275 Cumberworth Lane
Denby Dale
Huddersfield
HD8 8PT

22 August 2022

**Proposed Development at Cliff Hill Site Denby Dale off Cumberworth Lane.
Planning Application 2022/91911**

Proposed Section 1-1
Scale 1 : 100

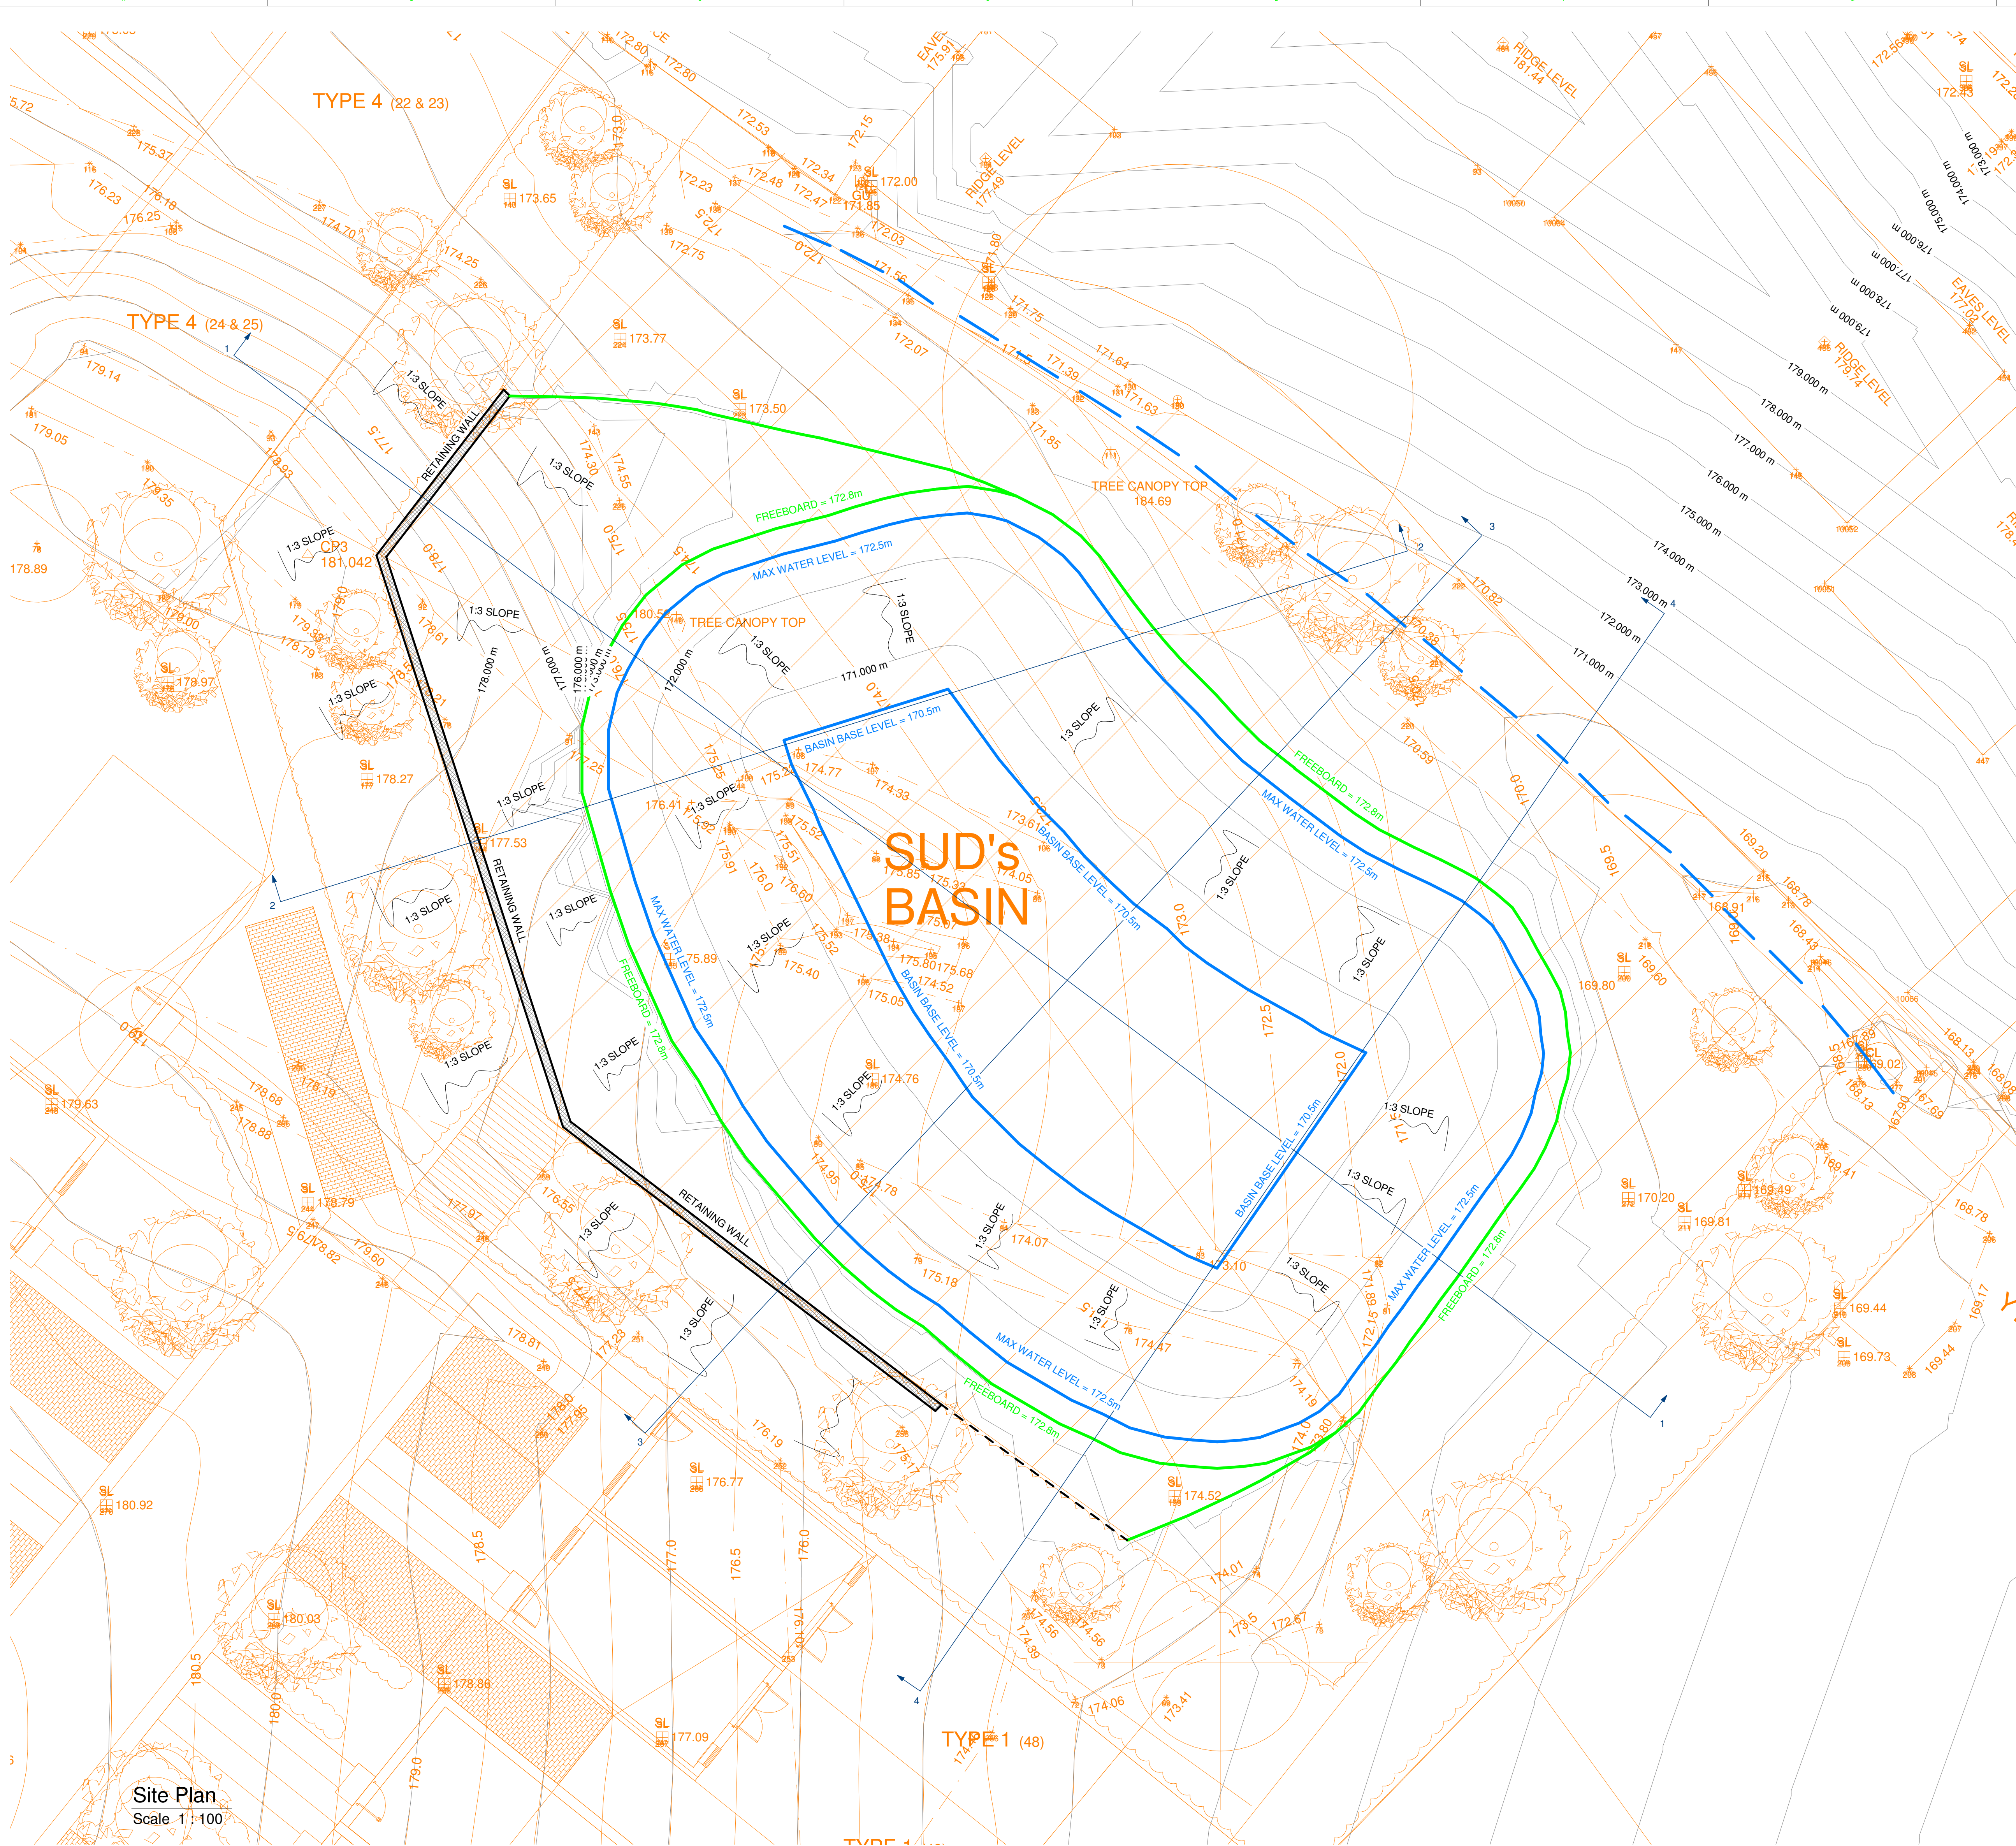
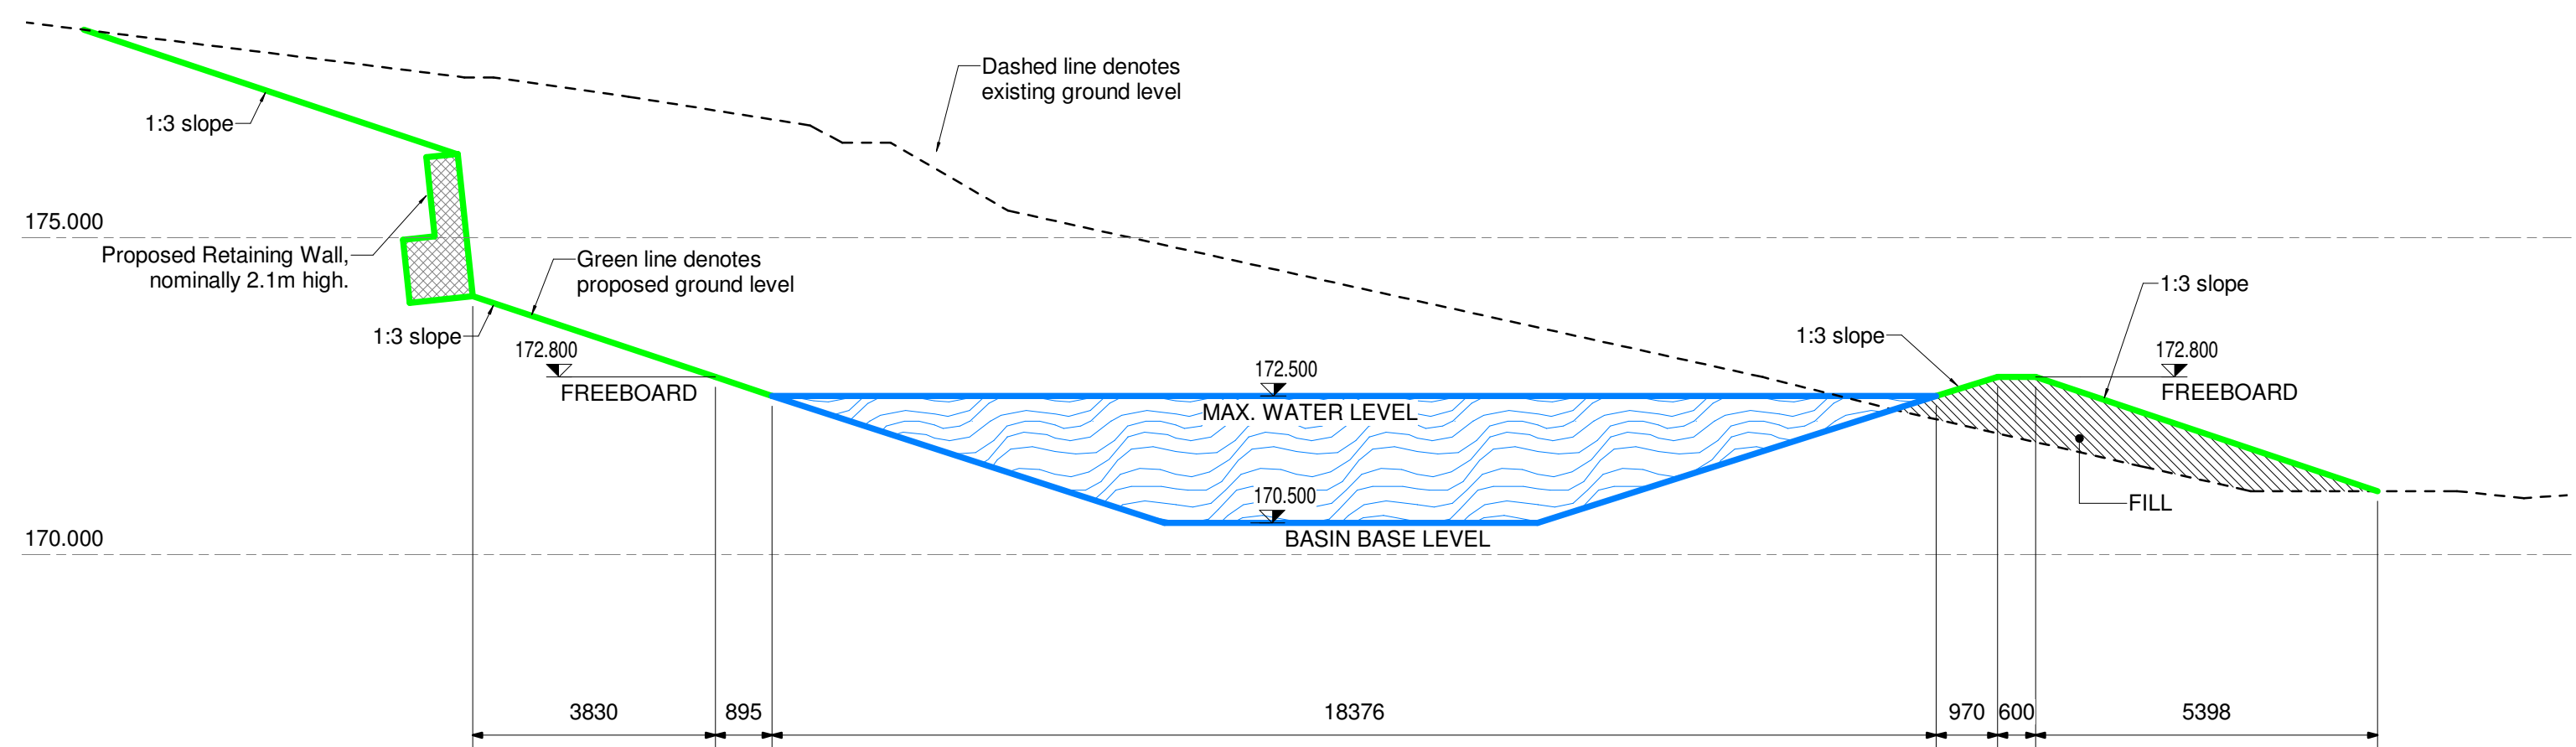
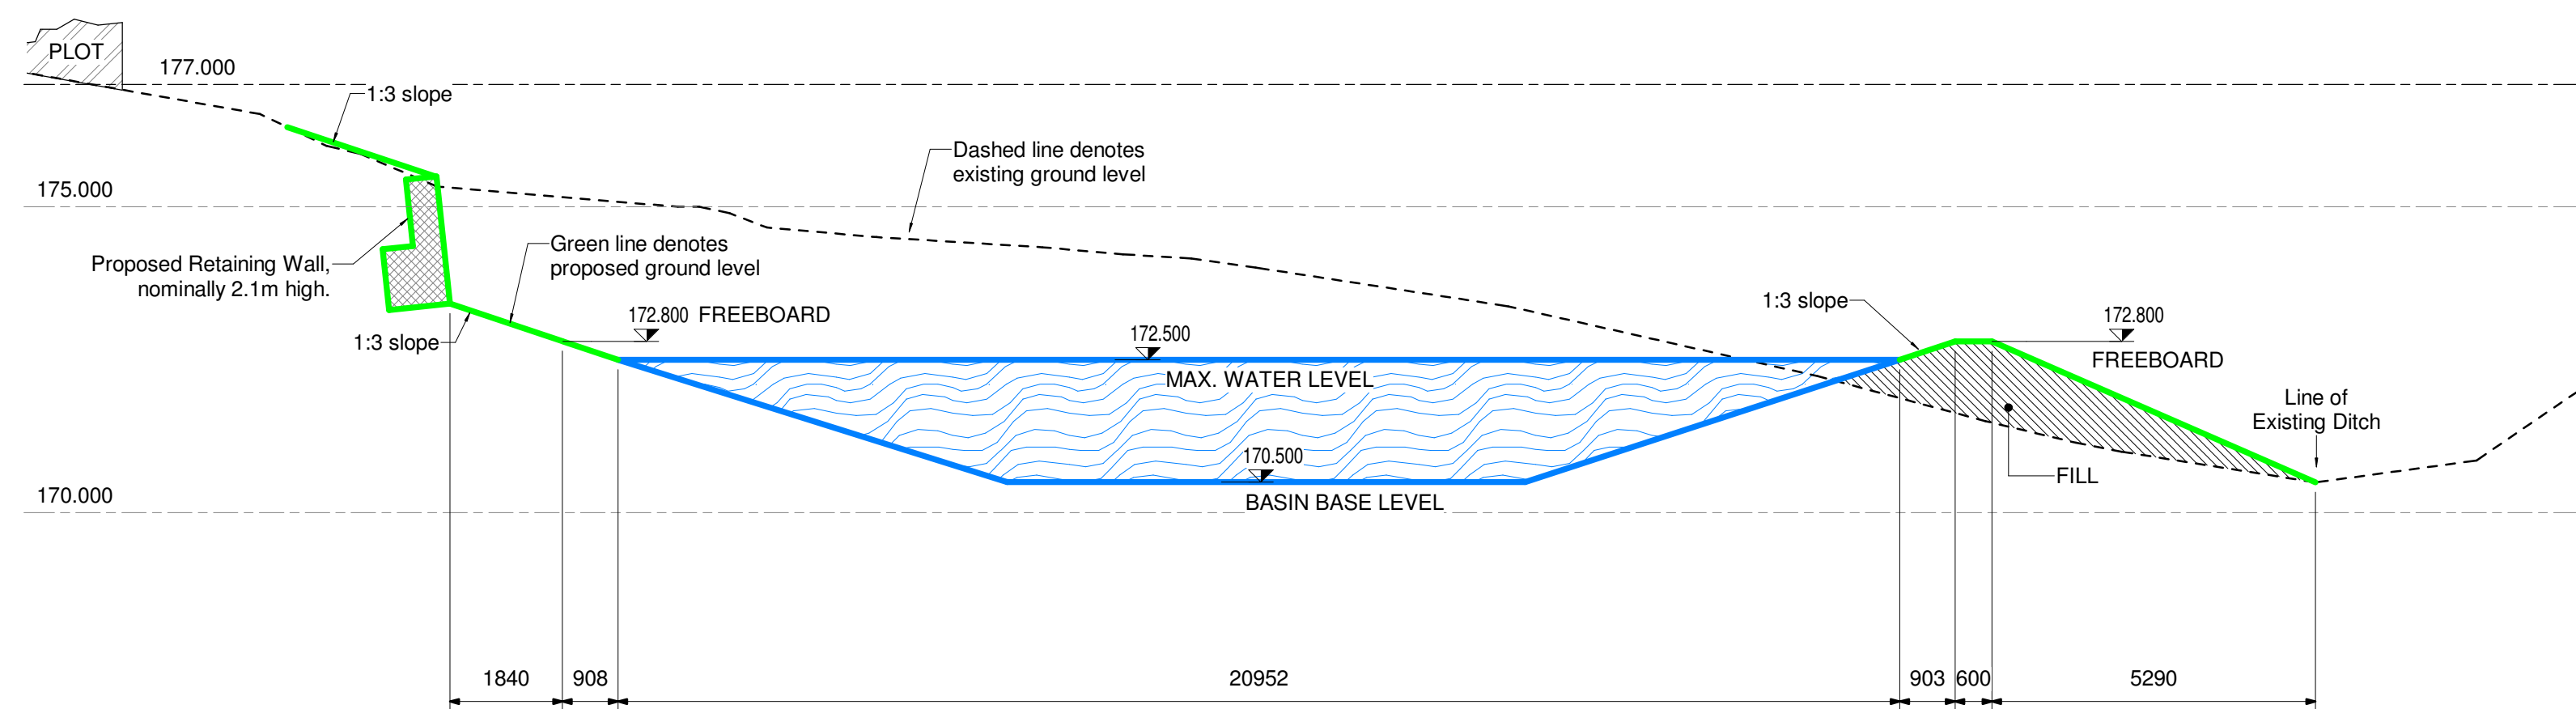
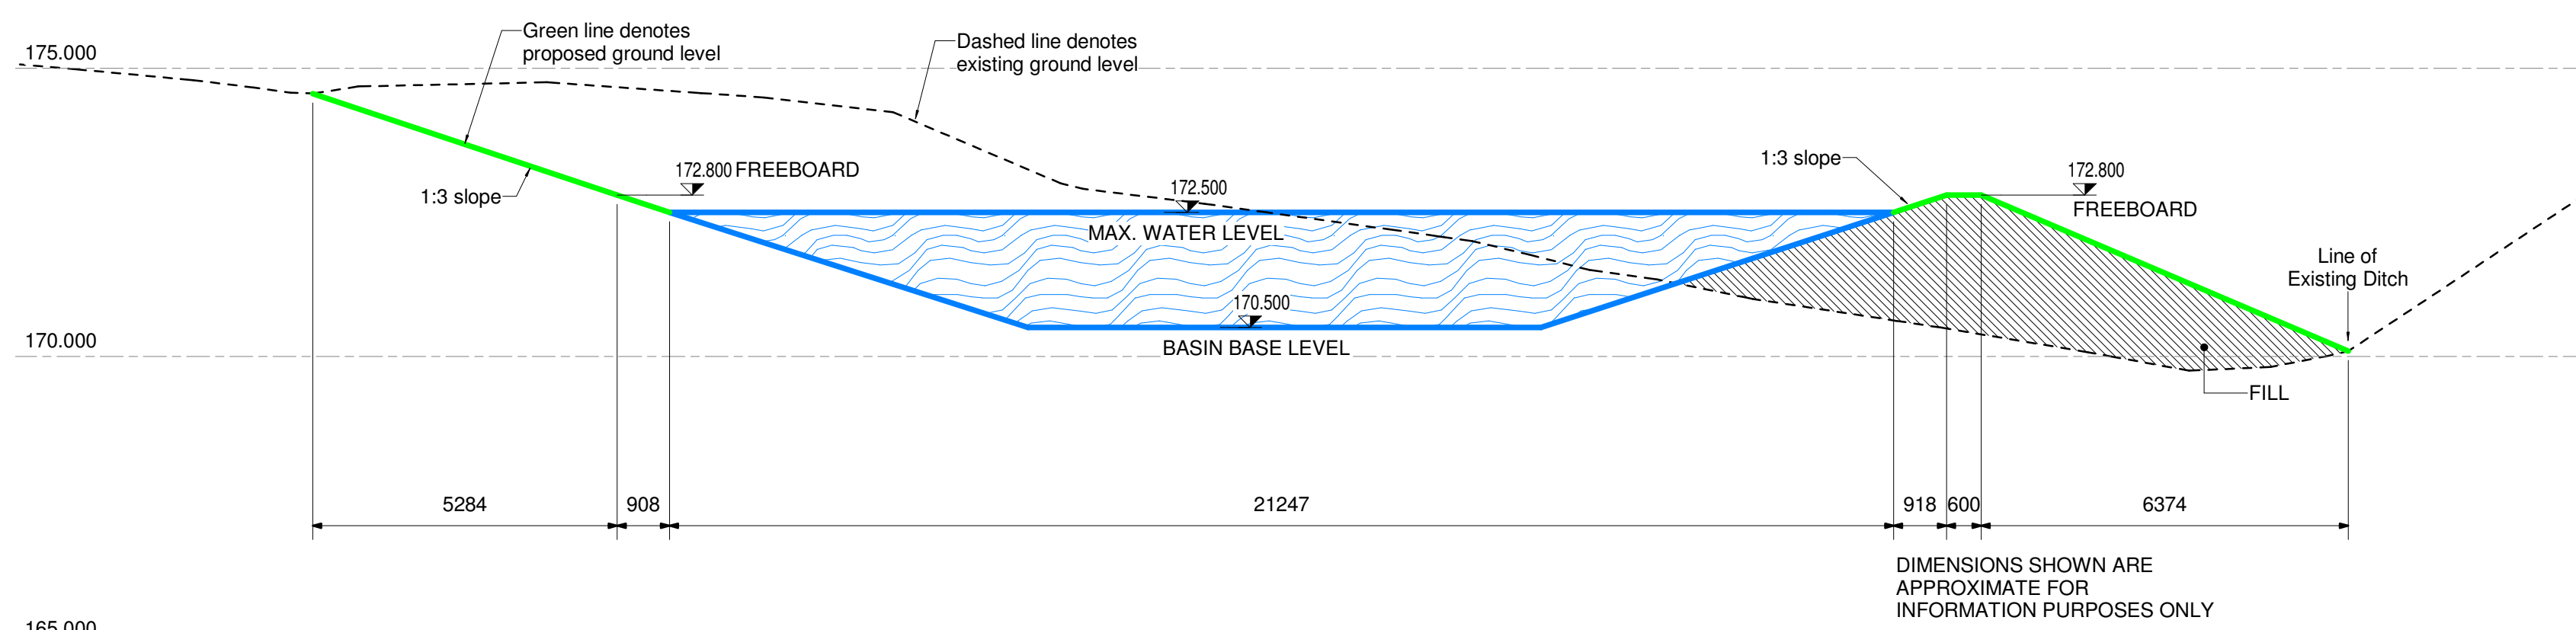
3. The proposal involves significant open cast mine workings to remove a coal seam approximately 1.4m deep. The excavation, compaction and associated vibration is likely to damage the existing surrounding properties. How will you the developer negate this risk ?
